Please ask for: Ms Iqraa Malik
Email: iqraa.malik@terraquest.co.uk
Telephone: 0121 234 1390
Our Ref: BE/8/22/L
Your Ref:
Date: 2nd February 2022

Listed Building Consent for Alterations, Extension or Demolition of a Listed Building

Development: Erection of single storey rear conservatory. (This application may affect the character and appearance of the North Bersted Conservation Area and a Listed Building).

Location: Dove Cottage 76 North Bersted Street Bersted PO22 9AQ

Plan view of proposed conservatory and part of existing building

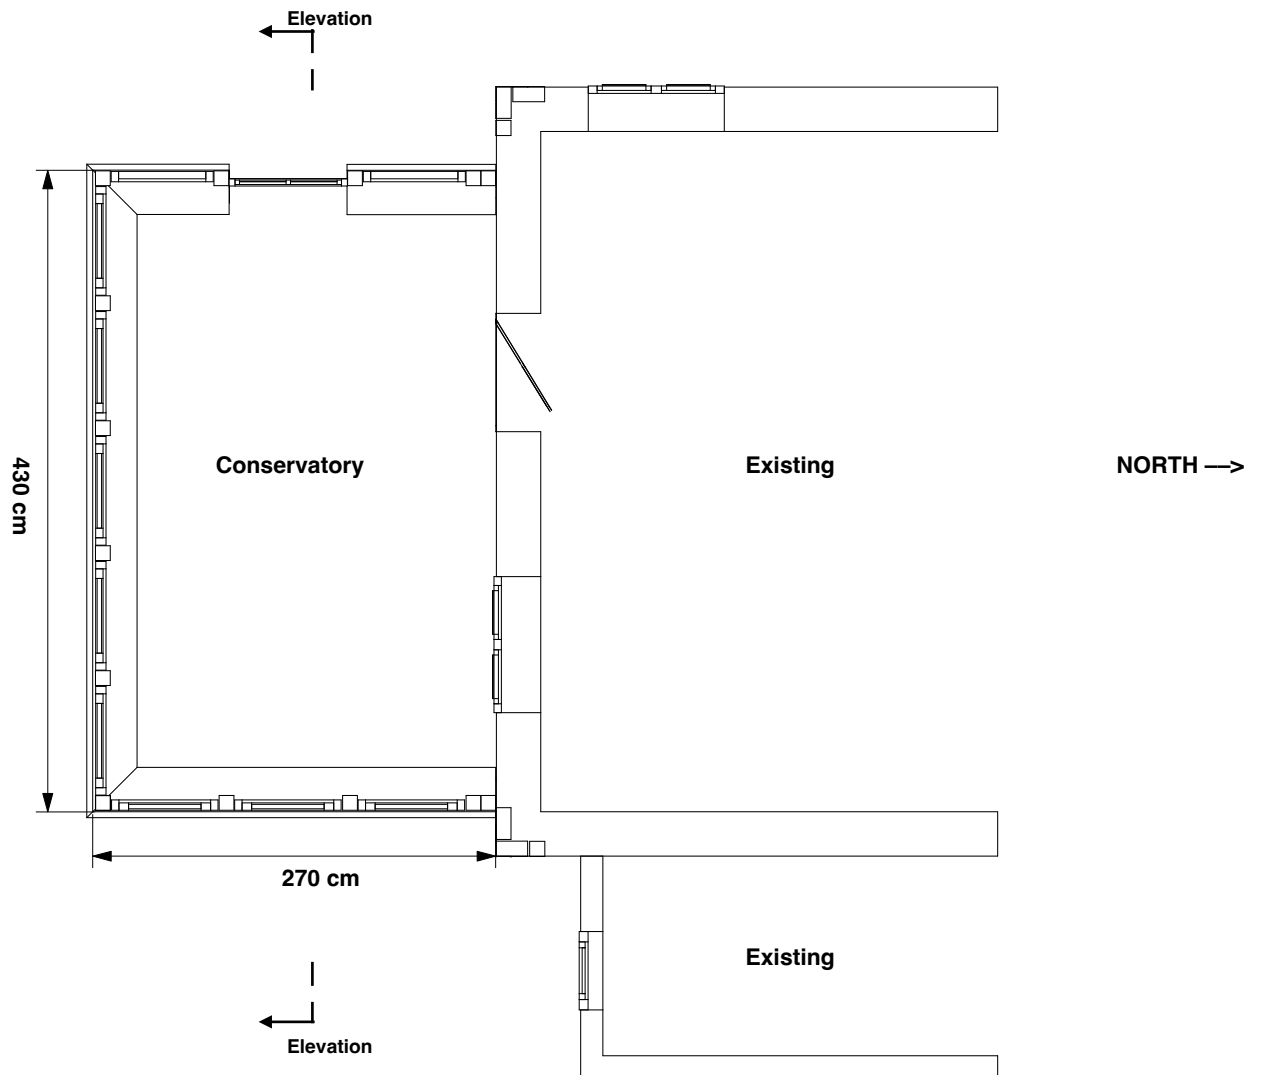
Please submit the proposed side elevations at a scale of 1:50 or 1:100. The proposed rear elevation must also show the existing rear window displayed on the proposed floor plan. Along with this, please add a scale bar to the proposed floor plans and elevations. Further details can be found in the Validation Requirements List.

Erection of conservatory

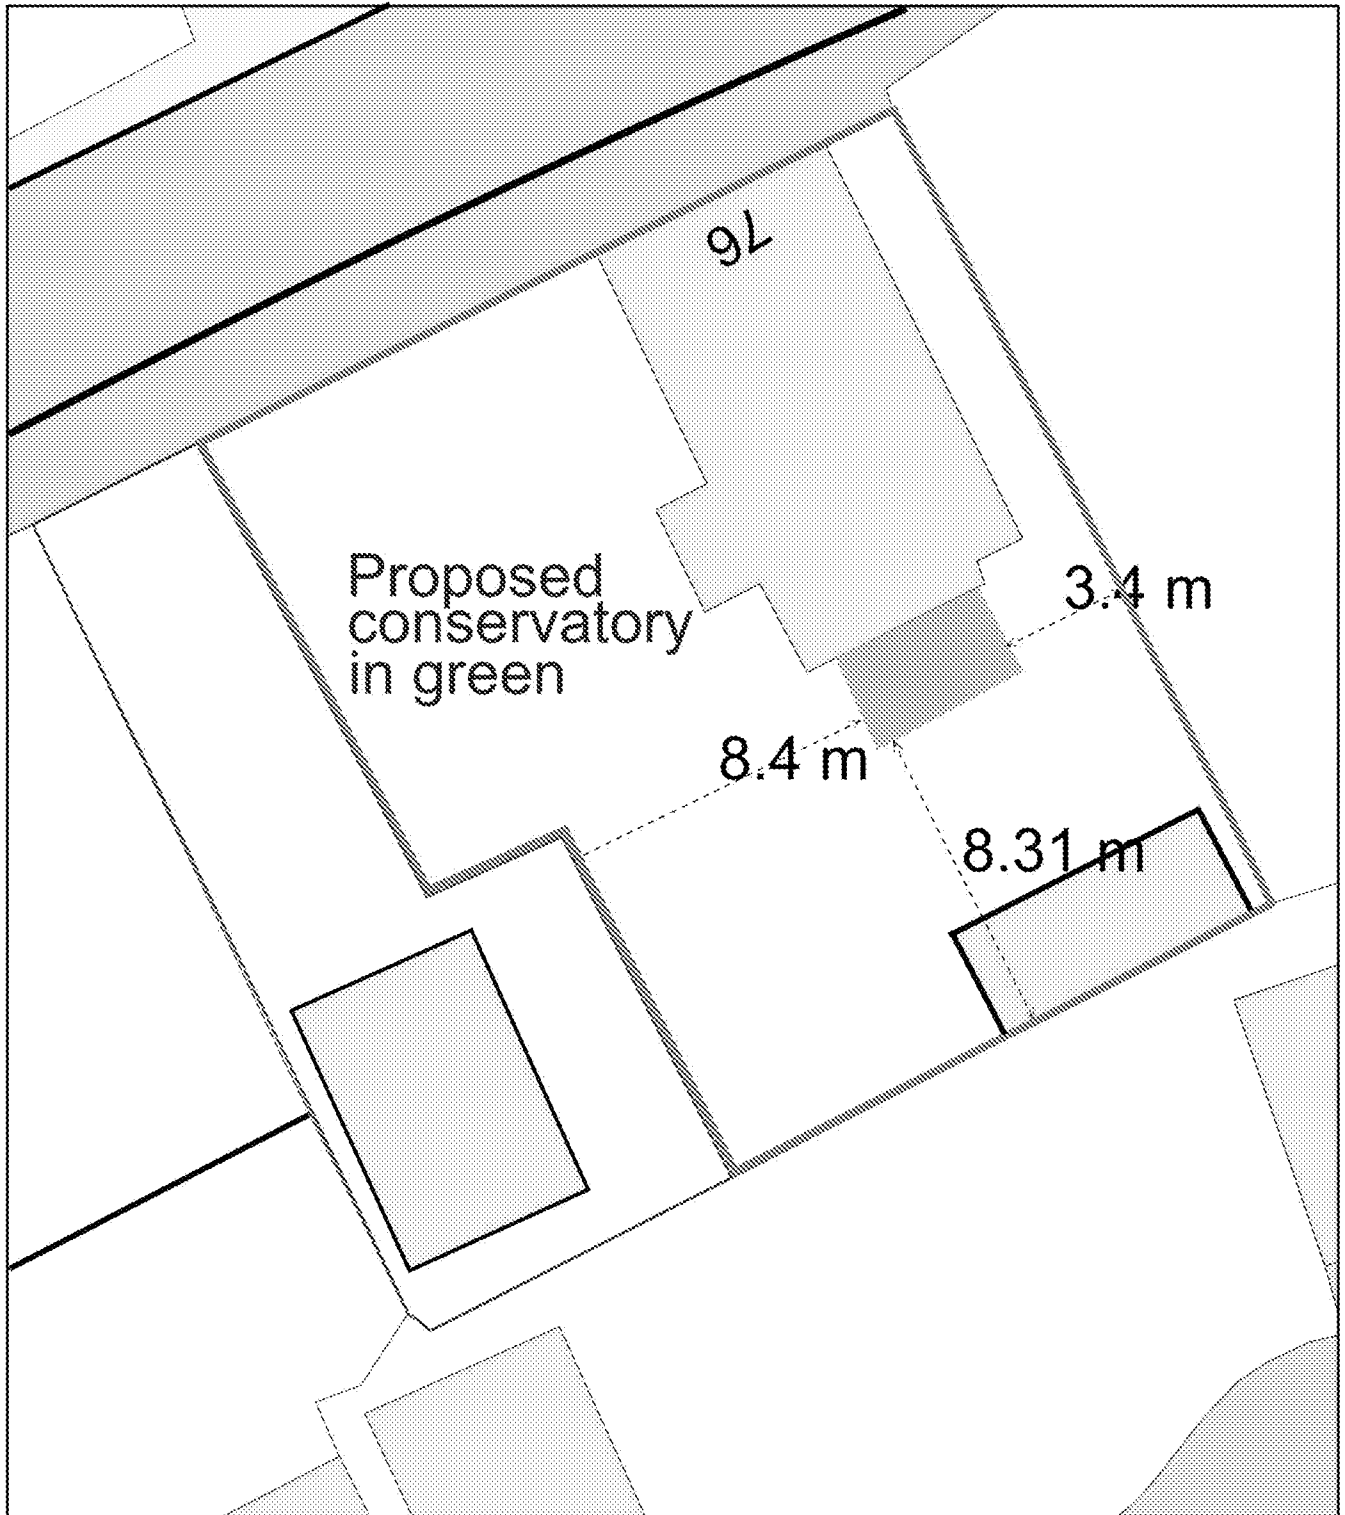
Please submit an electronic block plan with dimensions from the proposed extension to all site boundaries in pdf format at a scale of 1:500. Further details of what must be included on the plan can be found in the Validation Requirements List.
